## Jean Fraser - Re: Old Barn Estates - Deed Language Lot 6

**From:** Jean Fraser  
**To:** Biegel, Peter  
**Date:** 6/2/2015 3:59 PM  
**Subject:** Re: Old Barn Estates - Deed Language Lot 6  
**CC:** DiPierro, Philip; O'Donovan', 'Tim  
**Attachments:** As signed Subdivision Plan S-101 (2 of 2).pdf

**Jean Fraser - Re: Addressing for approved subdivision - 1062 Ocean**

Drawing file: final sign off / As signed Subdivision Plan 1 recording plan 1 of 2 (1).pdf

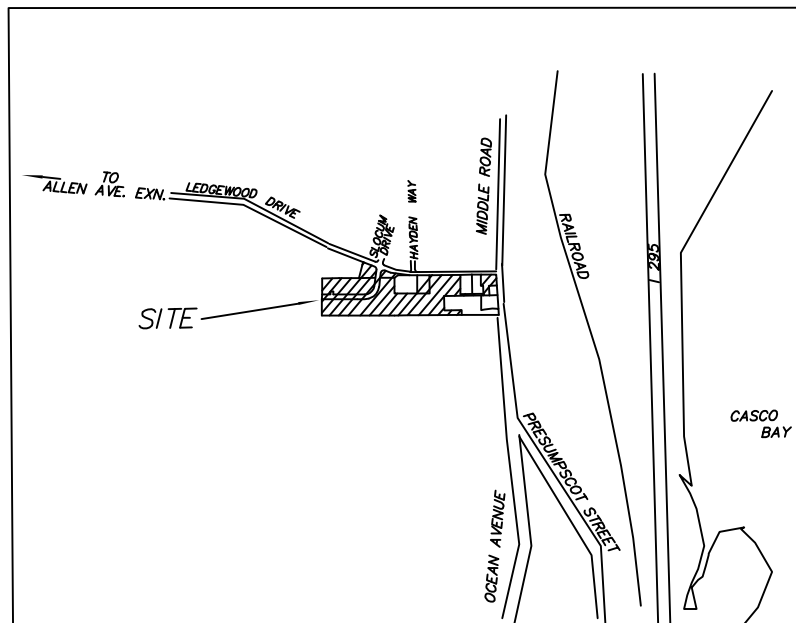
- 3) All of the easements (numbered 1-6 on the plat need to indicate who they are being conveyed to and they also need to specify in the notes that the City of Portland does not have any responsibility to maintain said easement areas (this would also include the public pedestrian easement - it should reference who that is being conveyed to and who will be maintaining said easement area);

- 4) the S-W buffer areas should indicate how large the area is, who maintains - and should also be included in the Homeowner's Bylaws; and
- 5) Lastly - in note 2 on the plat I think that the word "until" needs to be inserted into that sentence.
